Harnett County Department of Public Health Site Sketch

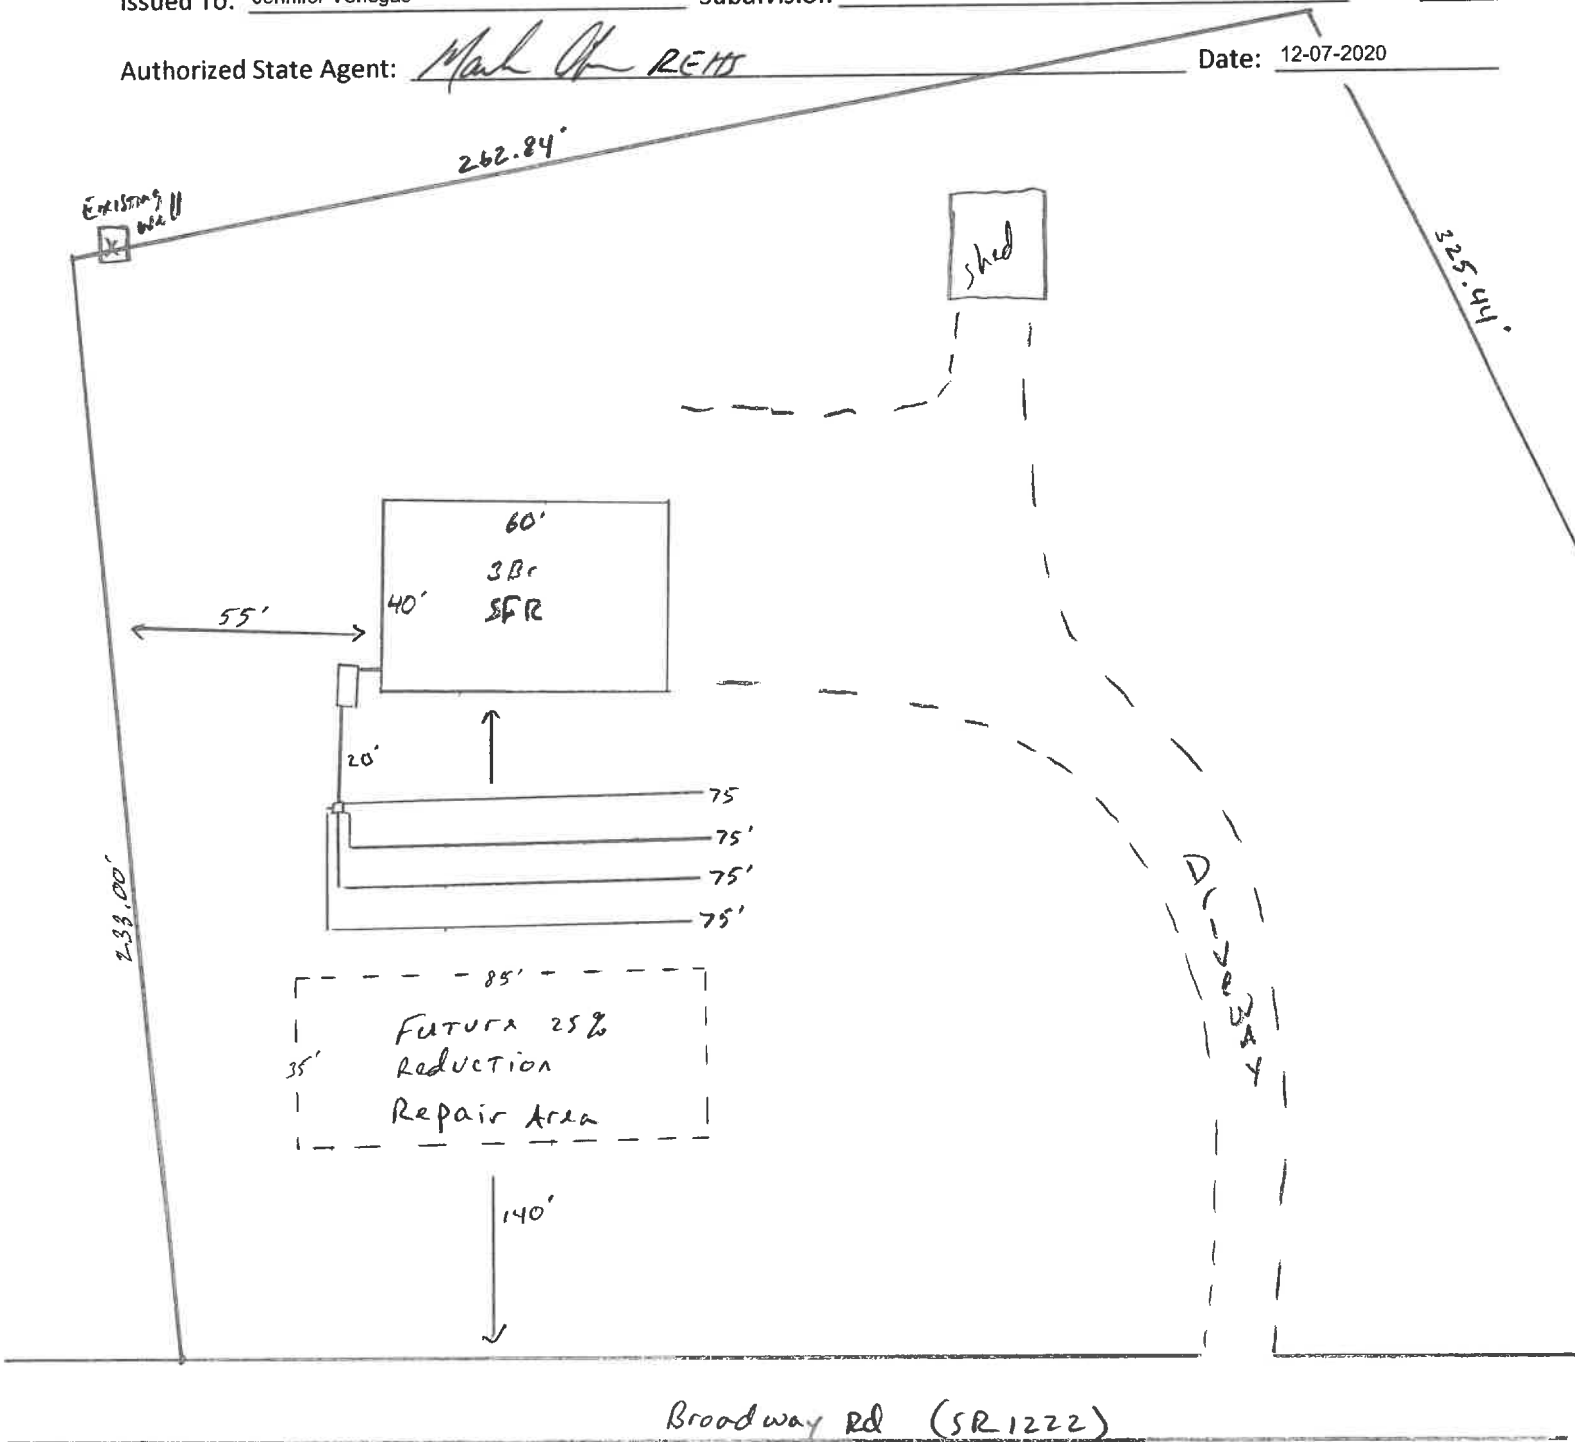
11-20-2020
 - Need All Irons Exposed
 - MUST know Accurately property lines

Show profile locations and other site features (dimensions, references or benchmark, and North)

12-2-2020
 Irons located
 (4) 75' x 3' Lines (25% red)
 18" x 24"
